11th December 2023
Revision A – 17th February 2024

Re: Land south of Barugh Green Road, Barnsley (MU1)
Planning Application 2021/1090 (Residential) & 2021/1089 (Hybrid)
Planning Submission of [REDACTED]

Figure 3 – Illustrative Masterplan

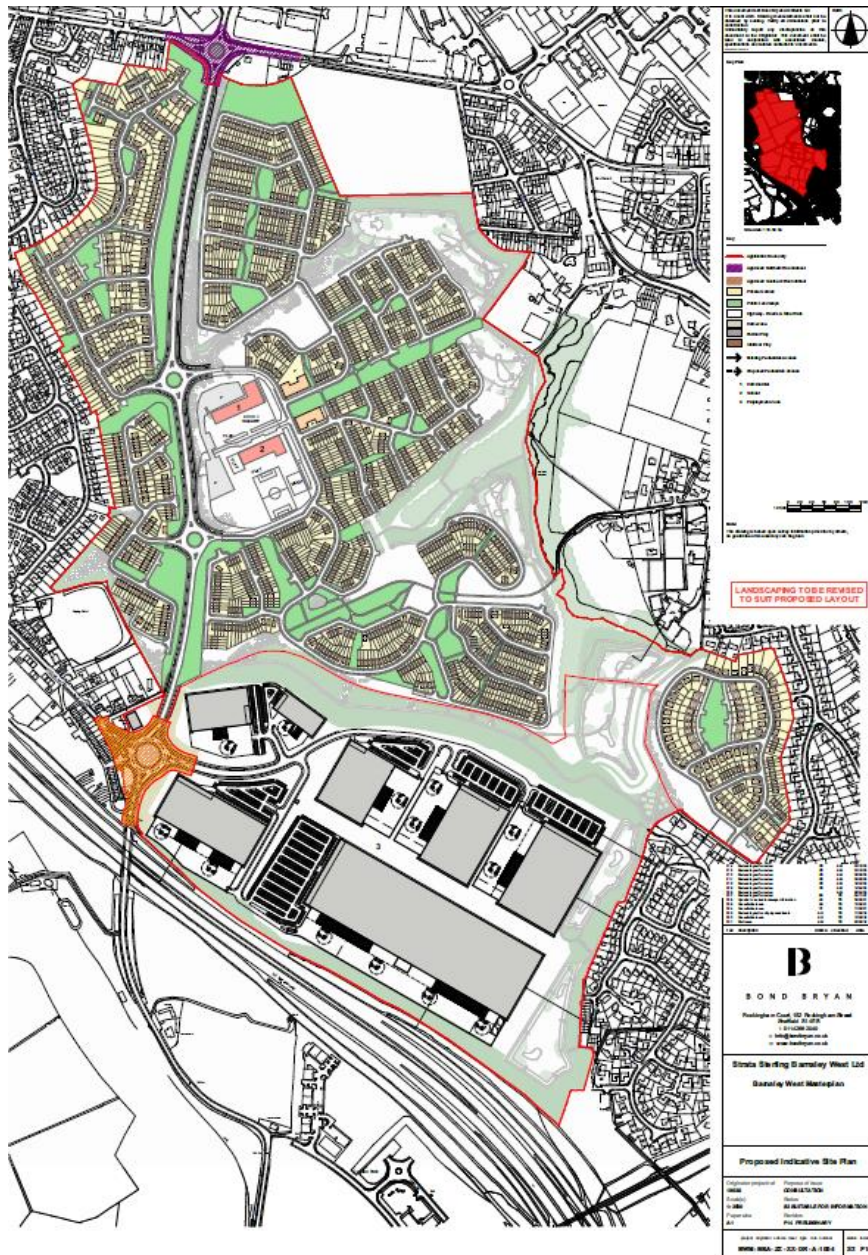
In the case of our properties on St Johns Avenue, immediately beyond our garden boundary the field slopes markedly upwards with uninterrupted vista as far as Higham and Pogmoor. The drawings provided with the latest application 2021/1090 clearly shows that large, 5 bed roomed, detached, 2 story houses are proposed for construction immediately adjacent to our rear (front) boundary.

Although I am unable to find a suitable sectional drawing for this part of Site MU1, it is abundantly clear that these new builds will completely block our outlook, overshadow our Rear (Front) garden, overlook our lounge and dining rooms, and will completely block the outlook and natural light from our lounge & dining room windows, completely destroying our privacy. *Proposed Regrade Contour Sheet-1 QD2088-00-300 clearly shows the significantly rising ground levels immediately beyond our rear (front) boundary*

In particular – the issue of 5 bedroomed detached two storey houses proposed, with the rear of the properties directly facing, and overshadowing the lounges & and dining rooms of our single storey bungalow (and those of several neighbours)

The construction of 2 story properties facing onto the front elevation of our existing bungalows will destroy the **outlook** we currently have the benefit of.

The proposals for 2 story properties abutting single story properties contravene the requirements of the Barnsley West Masterplan Framework (Bond Bryan November 2019)

There is no attempt to provide edge protection / boundary softening in order to integrate the proposed development in a sensitive manner with existing dwellings - as required by the adopted Masterplan Framework.

Figure 4: Parameters Plan

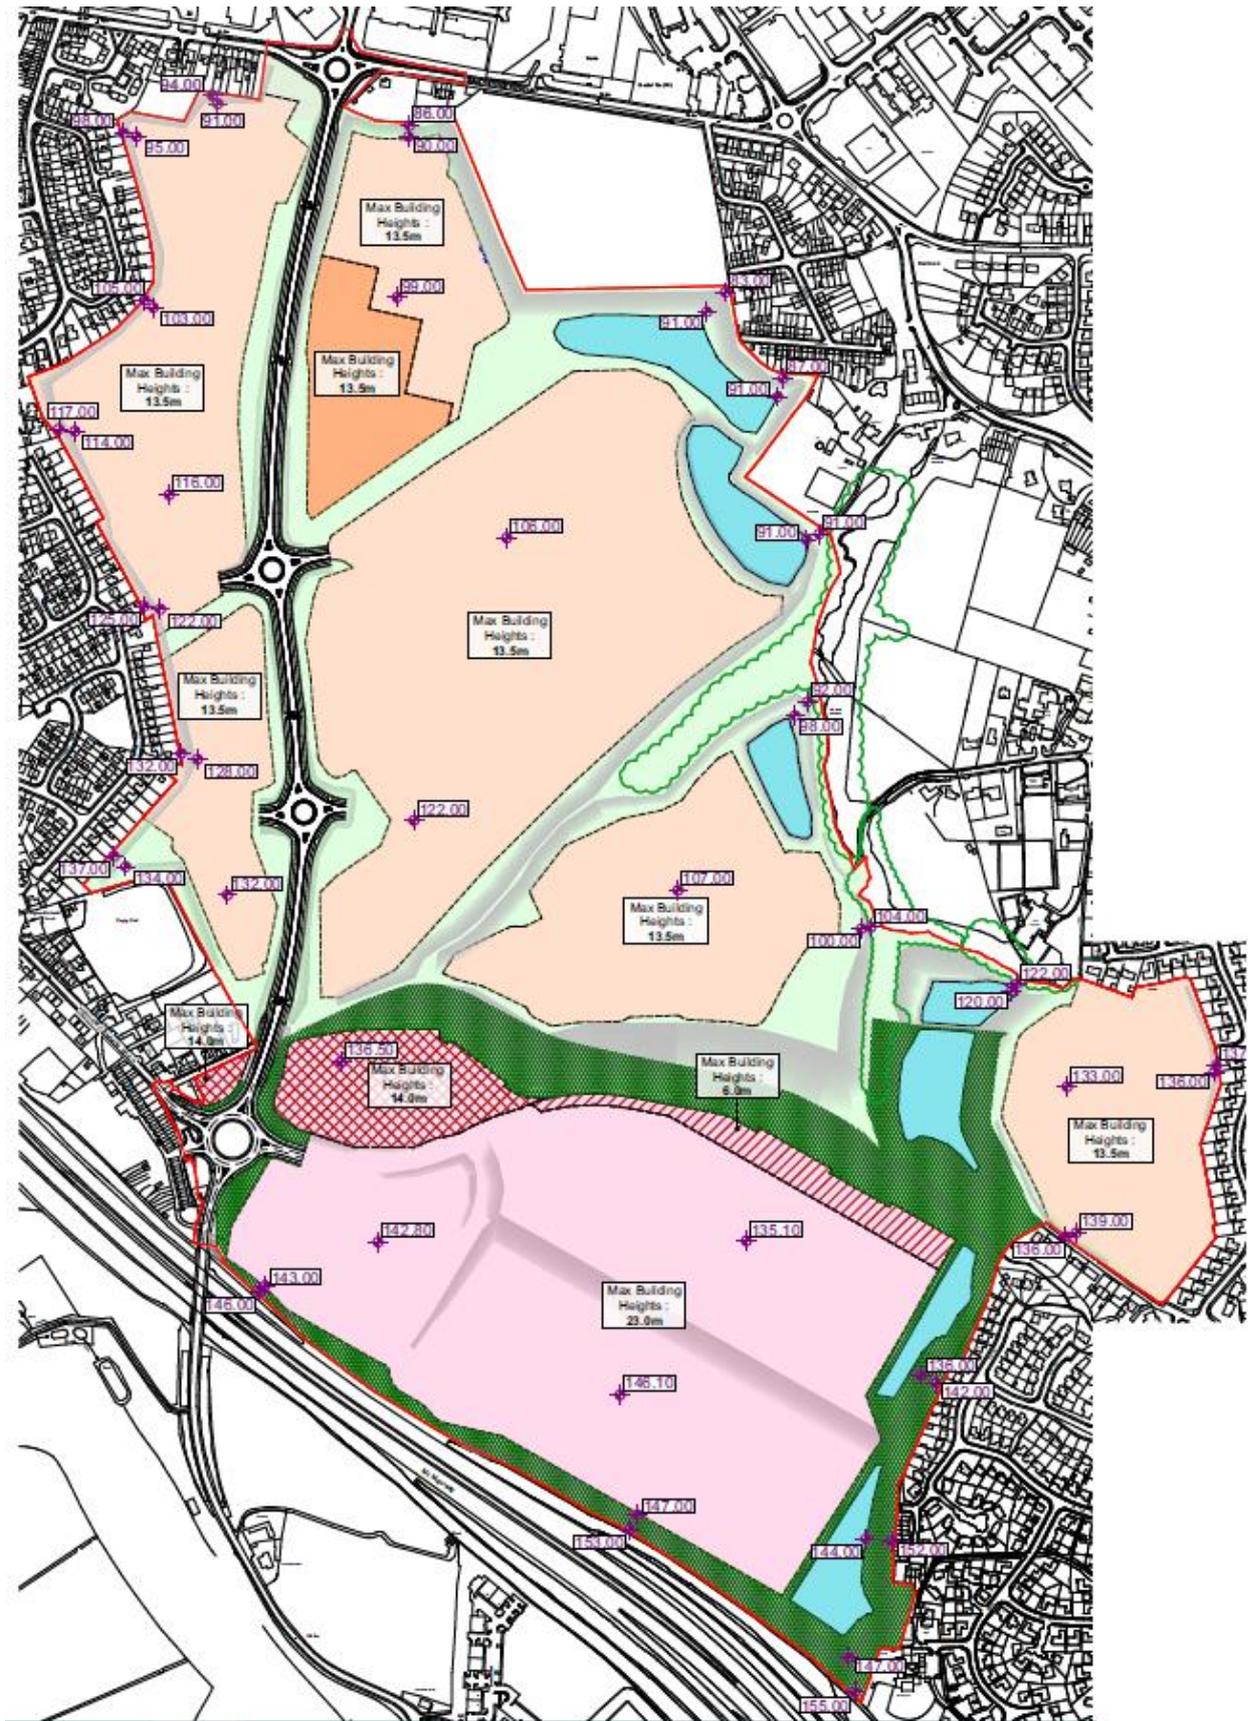
6.2. The huge industrial area shown on the plan is blatantly irresponsible. Much of this will be sited at the summit of rising ground and will be an ugly blot on the landscape from near & far viewpoints from the North and grossly overshadow existing properties in Pogmoor , Higham and Barugh Green, as well as any new housing built adjacent.
